14 May 2023

A66NTP - SCHEME 0405: TEMPLE SOWERBY TO APPLEBY TR010062
5.23 TRAFFIC REGULATION MEASURES
(SPEED LIMITS) PLANS (REV2) Submission Deadline 7. 11/05/2023
DCO Application
PINS Reference TR010062/APP/5.23
SHEETS 1-7 of 7

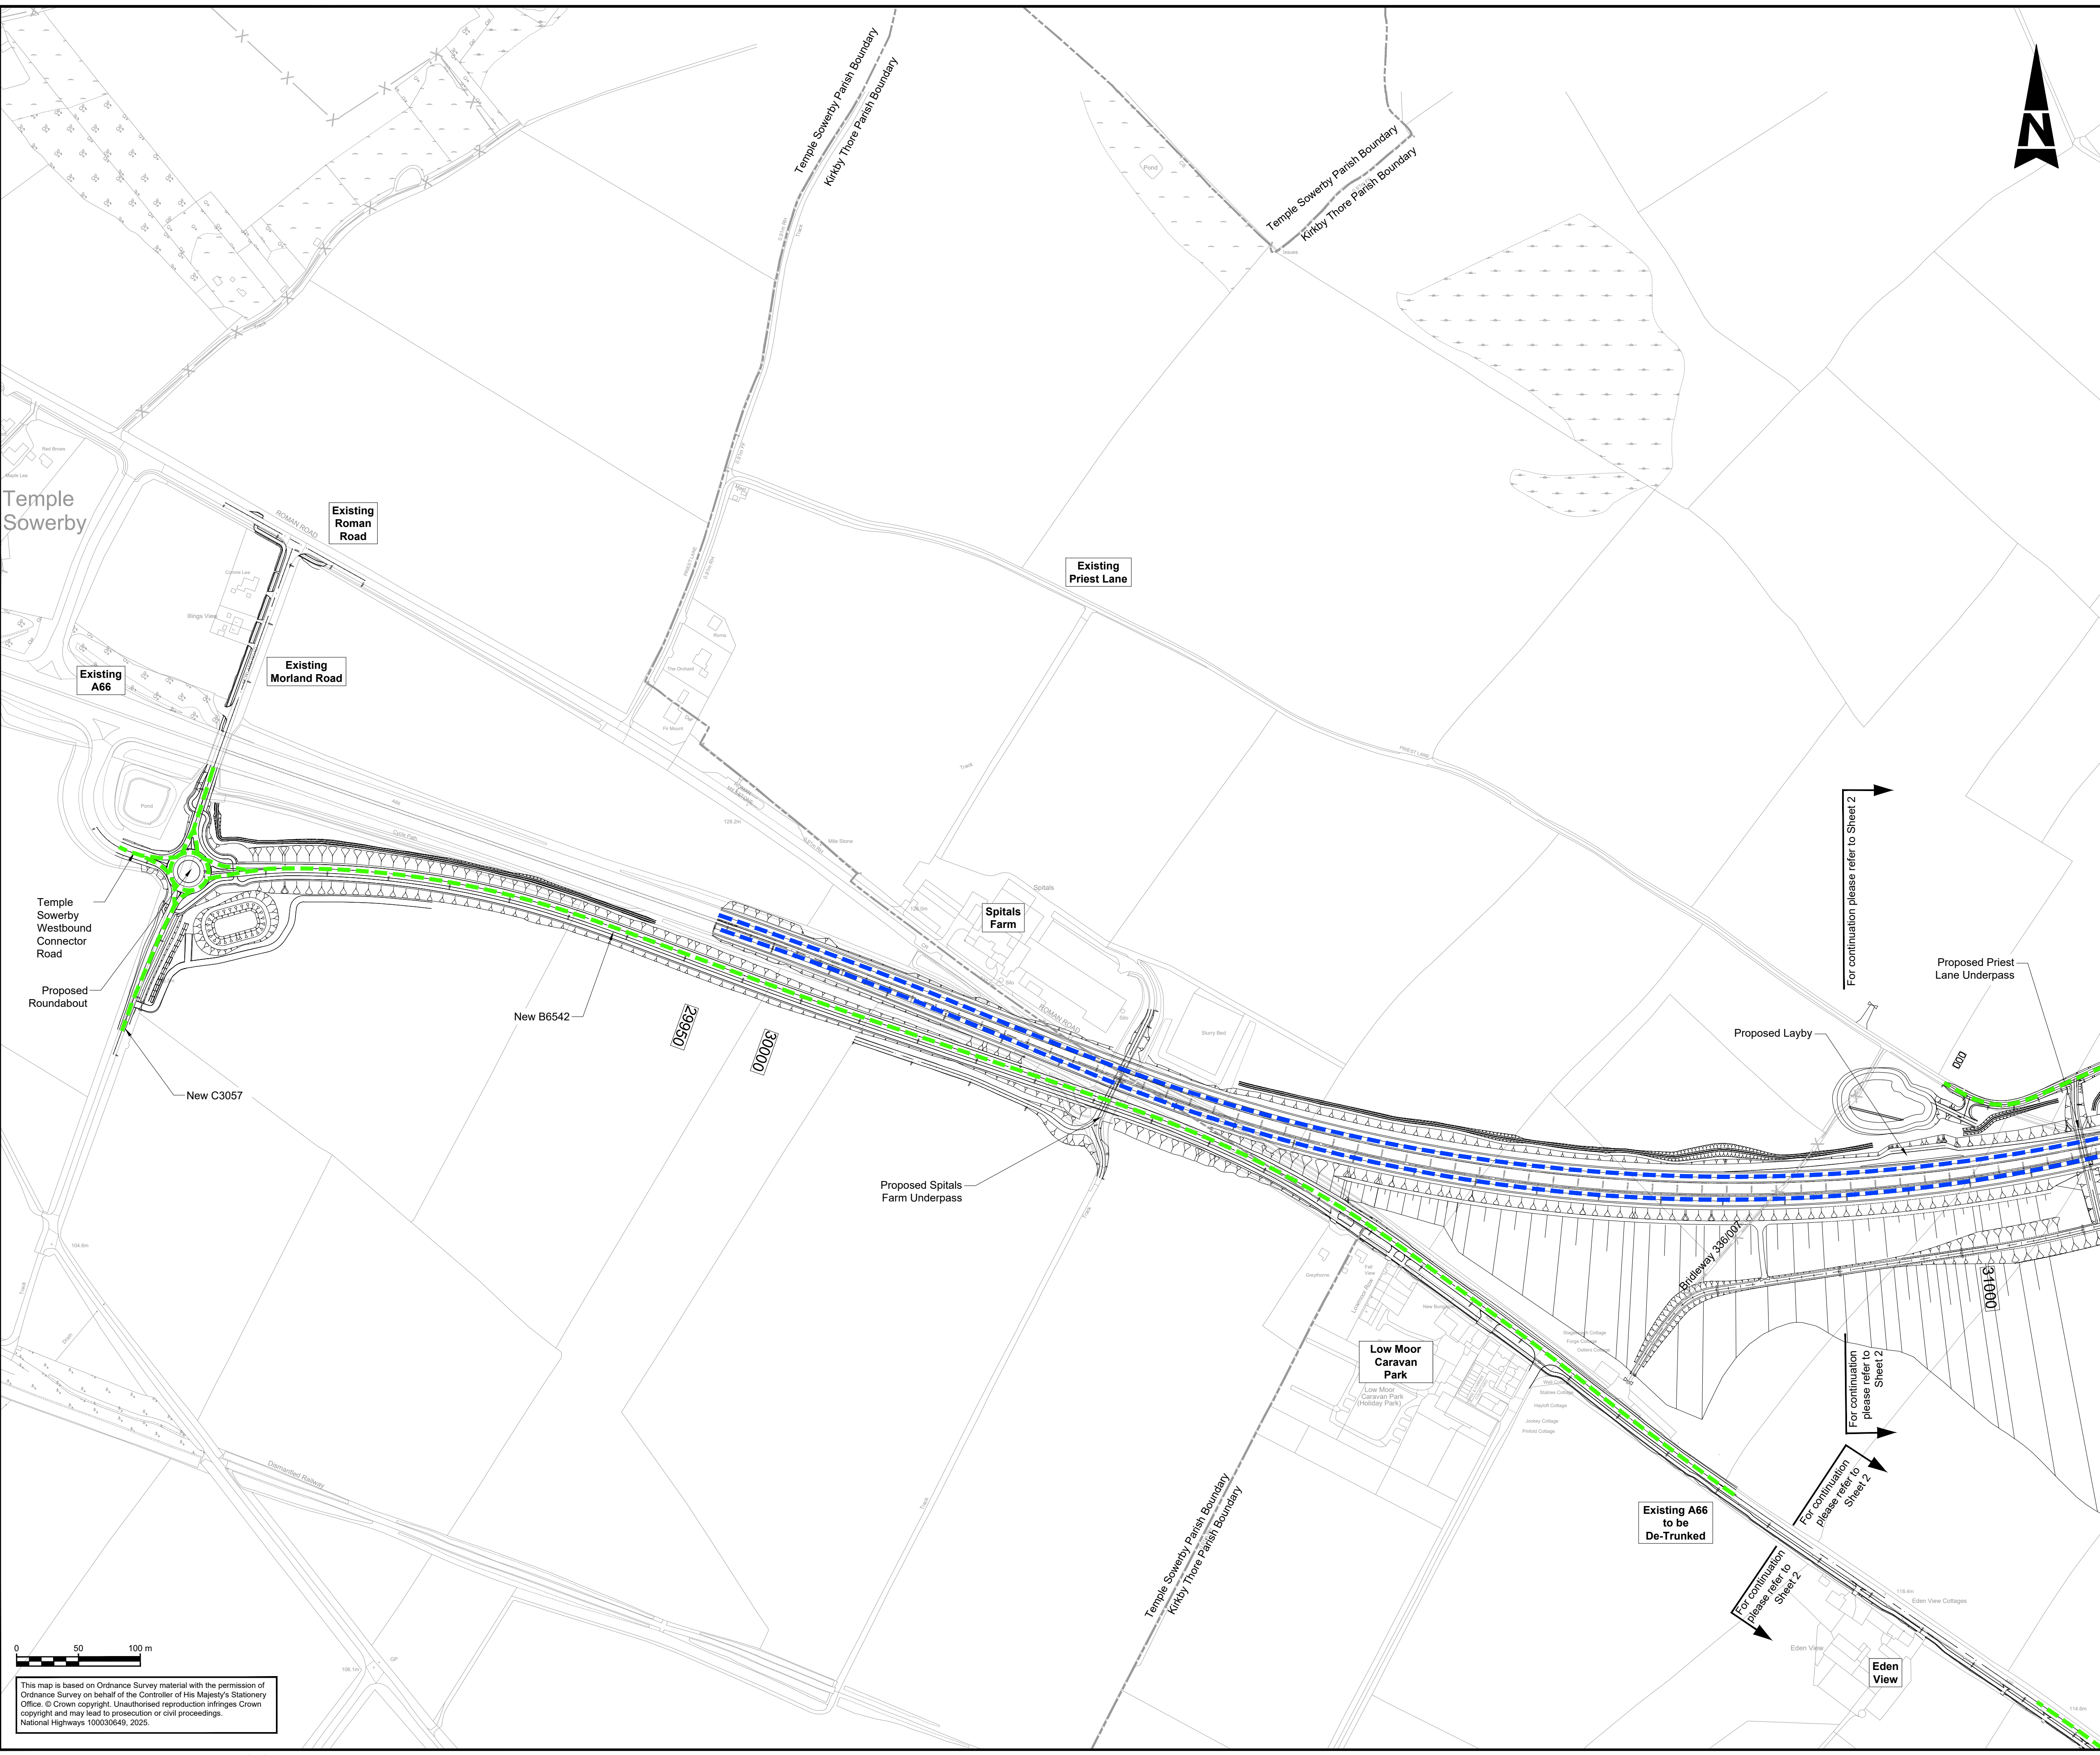
However, it is noted from the document mentioned above that the area of restriction is to be reduced with the new limit being from just east of Piper Lane junction to just east of the Filling Station. The reasons for this are unclear and, as a resident living within the current restricted area, it is felt unjustified.

Moving the commencement/termination of the restricted area to just west of Piper Lane, is questionable particularly as the well-used Piper Lane junction and two properties will be outside the restricted area. Within the proposed extended 60mph limit, there will be slow moving farm vehicles manoeuvring in and out of Street House Farm, Glenfield where there are 5 children and Piper Lane junction where vehicles entering the minor road must reduce their speed to a minimum to negotiate the corner. All creating a higher road safety risk.

With the reduction in length of restricted area (100 to 150m at both eastern and western end), the existing average speed limit cameras will become obsolete. Removal of the cameras would have a deterrent impact on vehicle speeds, road, and pedestrian safety. Surely, maintaining the current area of restriction would allow retention of the speed cameras updated to deal with the new speed limit. Transfer of ownership of the cameras from National Highways to the local authority would surely be possible.

One further item, it is noted that it is proposed to impose a 30mph speed limit along single carriageway Sleastonhow Lane. This proposal is not replicated for the new section of Priest Lane from Station Road. Our understanding is that this new section of road is to be wider than the existing Priest Lane so there is the expectation that vehicle speeds will be higher than on the narrow Sleastonhow Lane. Surely there is a need for the new wider Priest Lane to be restricted to 30mph too on the grounds of safety of walkers, cyclists, and horse riders.

Similarly, if speed limits in the village are being addressed as part of this project, perhaps it is opportune to include a 30mph restriction on Piper Lane.
